Project Name: Century Tire Plaza

Project Address: 195 Kennebec Str.

Project Name: Century Tire Plaza
Address: 195 Kennebec Street, Portland, ME
Project ID: 2015-027
CBL: 34-C-9
Applicant: Northland Enterprises, LLC
Planner: Nell Donaldson

On April 14, 2015, the Planning Authority approved with conditions a Level II site plan for the redevelopment of the Century Tire site at 195 Kennebec Street. The decision is based upon the application as submitted by Northland Enterprises, LLC and prepared by FST, Inc., with plan revisions dated April 1, 2015. The proposal was reviewed for conformance with the standards of the City of Portland's site plan ordinance, Article V of the land use code. It should be noted that the plans for the project's Marginal Way and Kennebec Street frontages were found to meet the guidelines of the Marginal Way Master Plan and the Somerset Street Extension Feasibility Study respectively, and that the provision of the sidewalk along the property's eastern boundary was found to meet the city's B-7 and site plan standards related to street connectivity and safe access for all site users. The Level II site plan is approved with the following waivers and conditions:

SHEET TITLE: SITE LAYOUT AND UTILITY PLAN

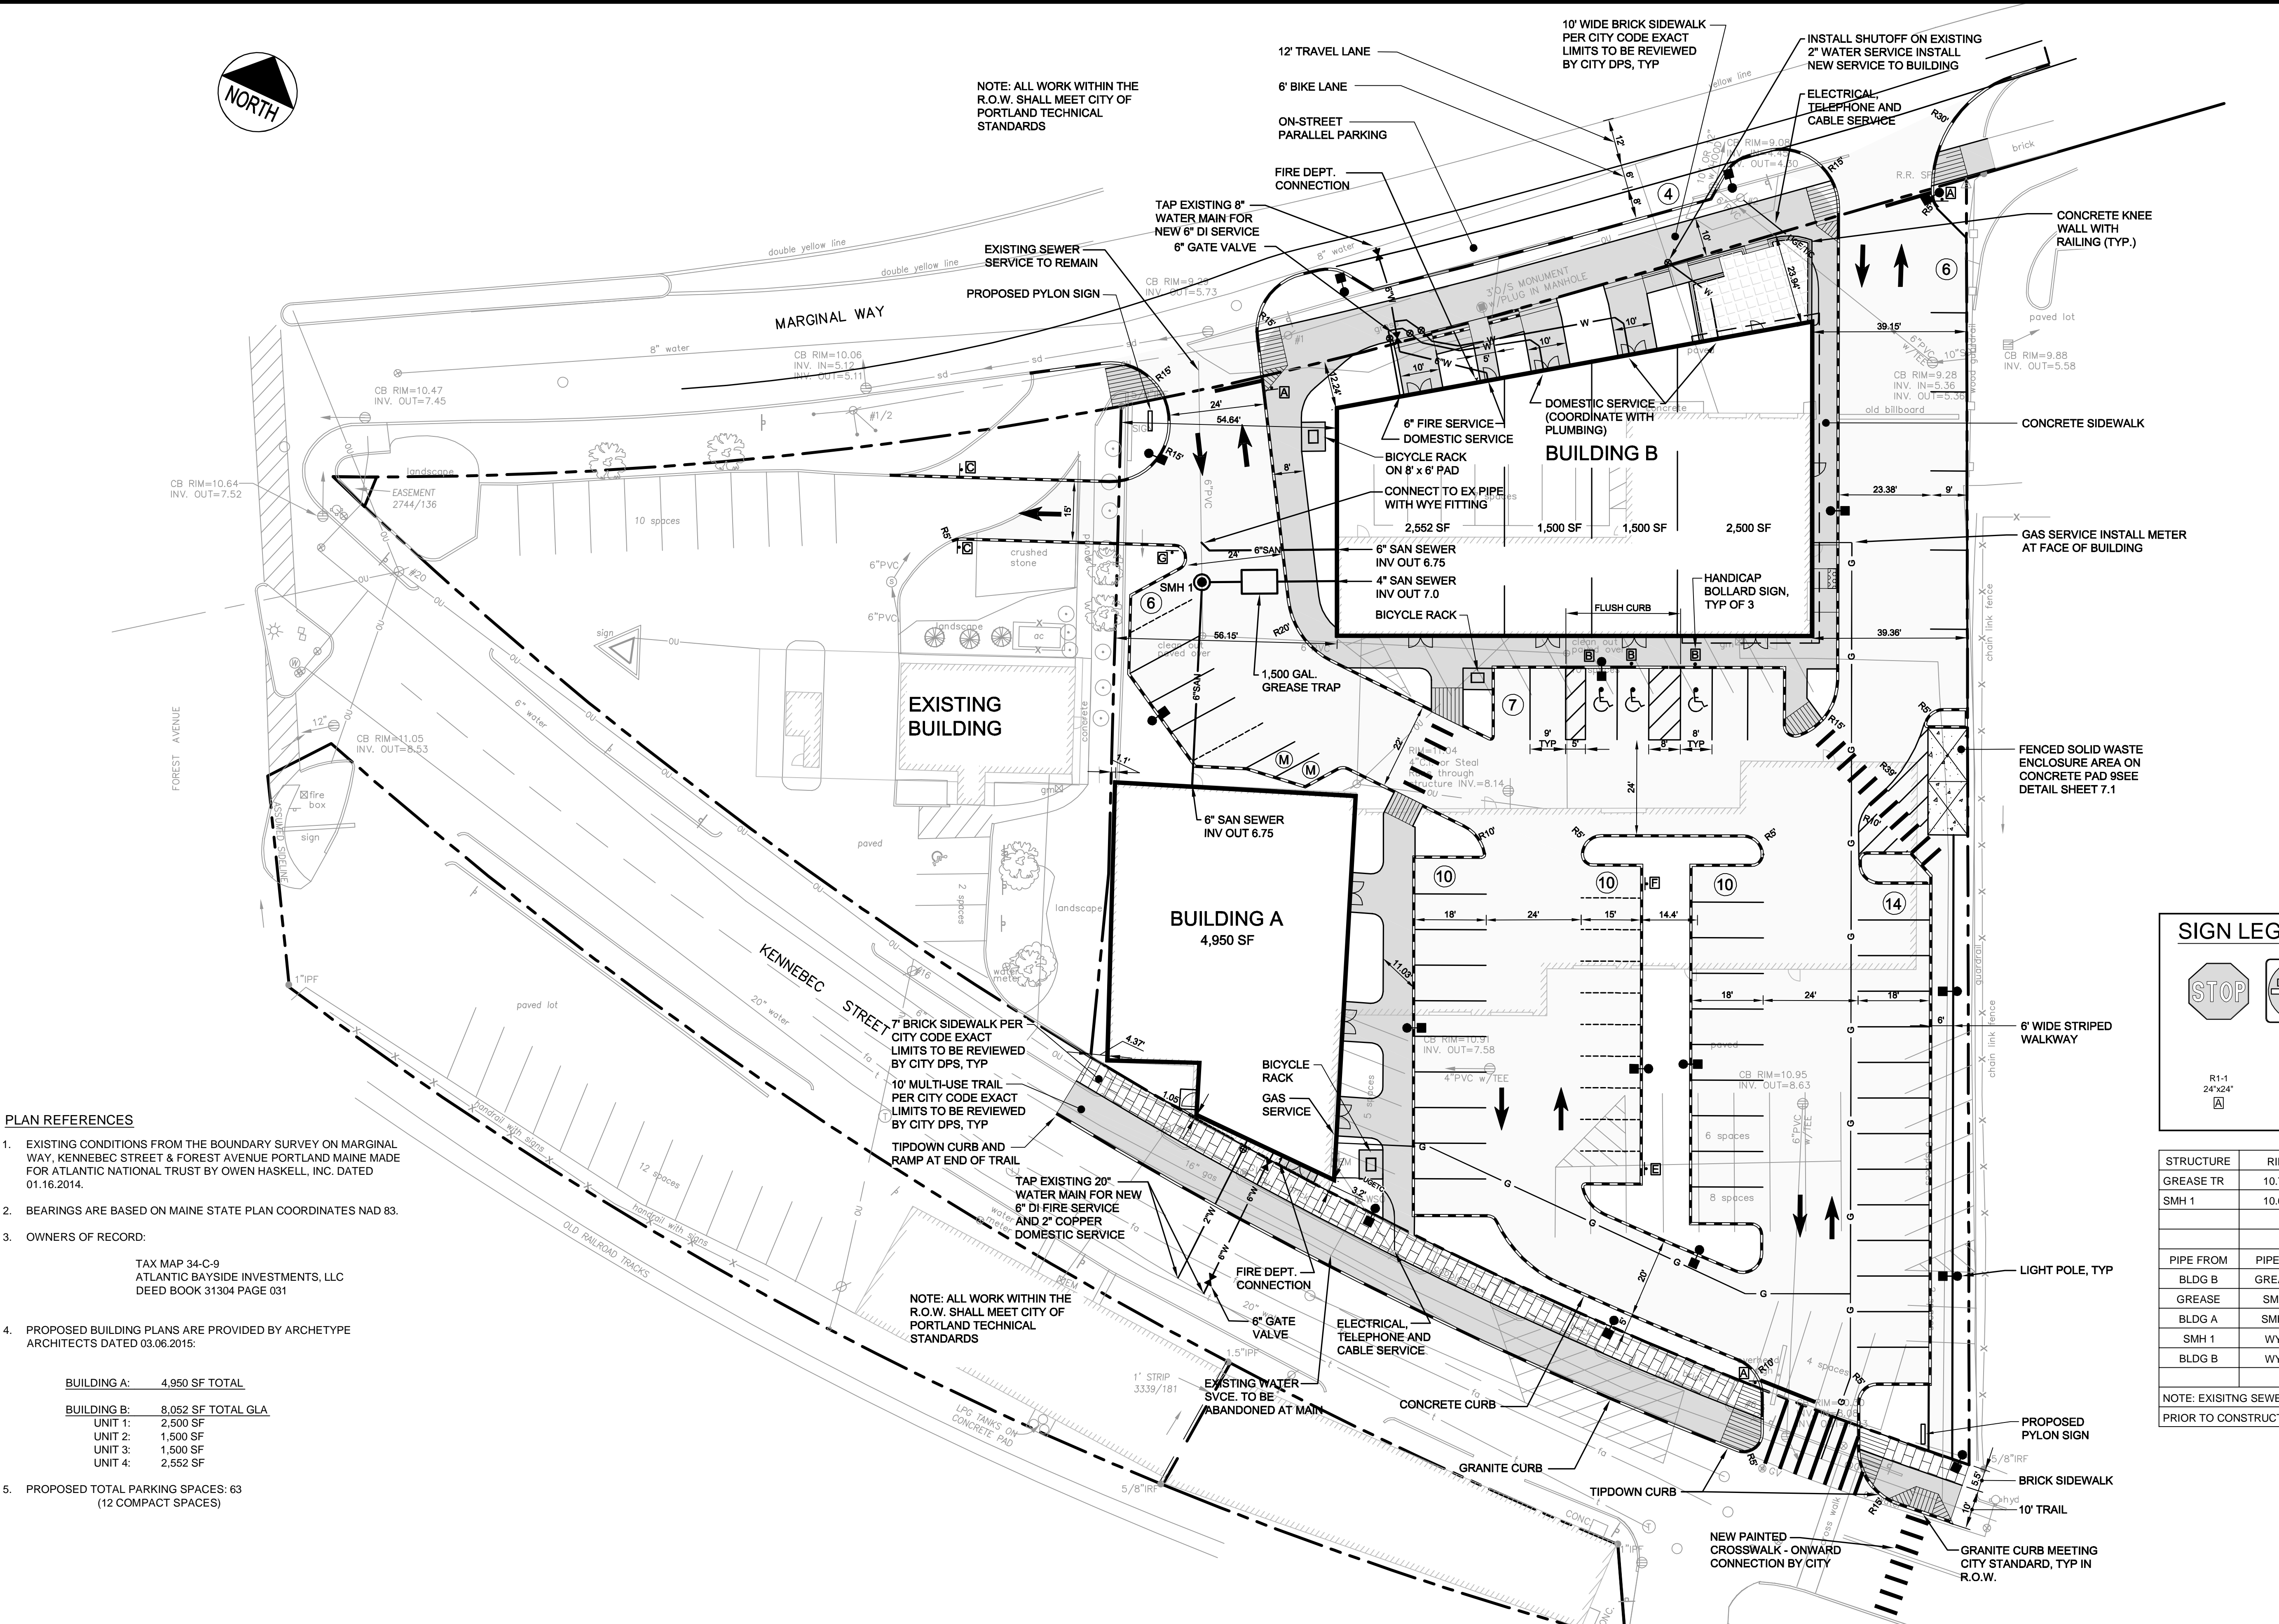
1. The applicant shall revise the plan set for review and approval by the Department of Public Services, including:
 - A modified design for the Marginal Way sidewalk, to include a reduction in sidewalk width to 8 feet and the expansion of the esplanade by 2 feet, in order to match conditions east of the site;

- A curb extension west of the westerly driveway on Marginal Way and transitional pavement markings for bicycles and vehicles from Forest Avenue;
 - Details that confirm ADA accessibility and reasonable pedestrian access along and to the Marginal Way frontage of Building B;

- A mechanism to prevent parked vehicles from encroaching on the sidewalk along the eastern boundary of the site;
 - Alternate snow storage locations designed to avoid conflicts with pedestrian movement on the sidewalk along the eastern boundary of the site;

- A curb extension on Kennebec Street at the location of the sidewalk ramp/crosswalk such that the handicap ramp is not located within the 10-foot path area;

- An ADA compliant ramp on the south side of the crosswalk on Kennebec Street in this location; and
 - Pavement markings, signage, and bollard treatments in conjunction with the transition from the 10-foot shared-use path on Kennebec Street to an at-grade cycle-track facility west to Forest Avenue.

(A) N.T.S.

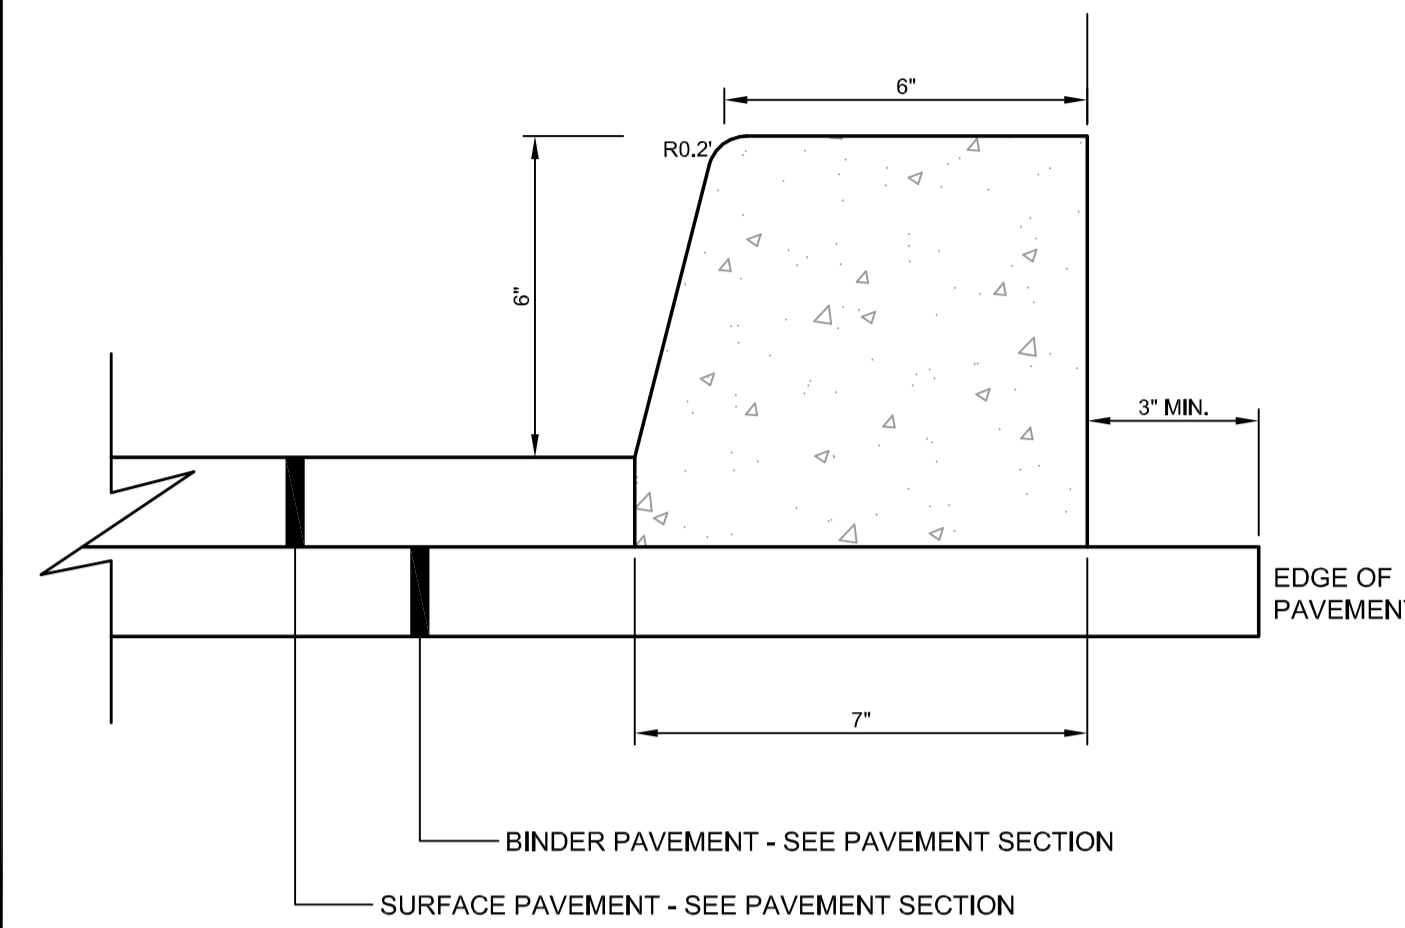
Detail A on plan sheet C-7.1 shows a curb reveal of 6 inches along Kennebec Street. The City standard for curb reveal is typically 7 inches. The curb reveal should be changed to match the City standard unless there are over-riding considerations that require a 6 inch curb reveal. A change to 6 inch curb reveal may require changing the specification for granite curb terminal pieces from 6 feet to 7 feet in length.

- done 4/12/15
6. The applicant shall revise details to depict the city's standards for curb reveal and depth of base gravel for a brick sidewalk on bituminous base for review and approval by the Department of Public Services;

BRICK SIDEWALK WITH BITUMINOUS BASE

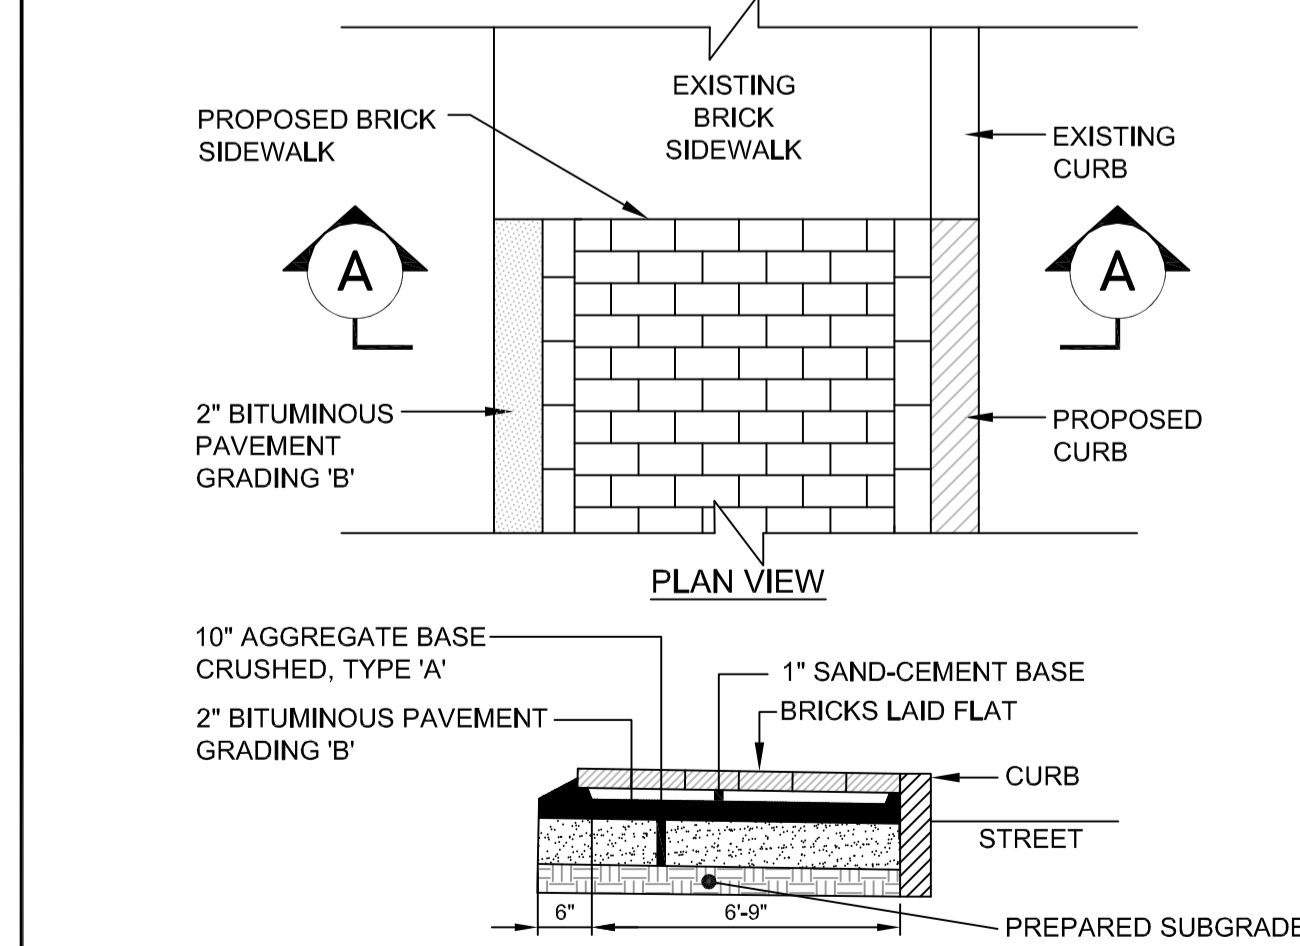
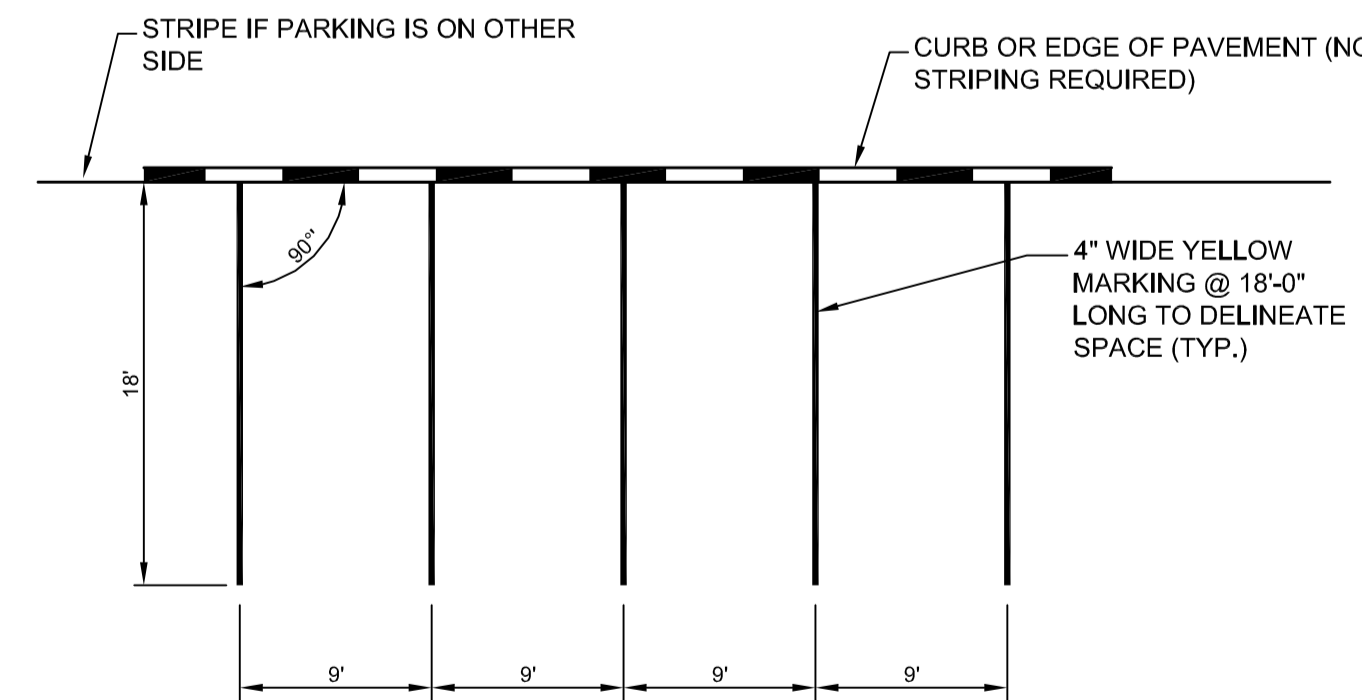
Detail C on plan sheet C-7.0, detail D on sheet C-7.2, and detail E on sheet C-7.2 all should be corrected to show the City standard for depth of base gravel for a brick sidewalk on bituminous base. The depth of gravel should be 10 inches, not 4 inches as indicated in the above referenced details.
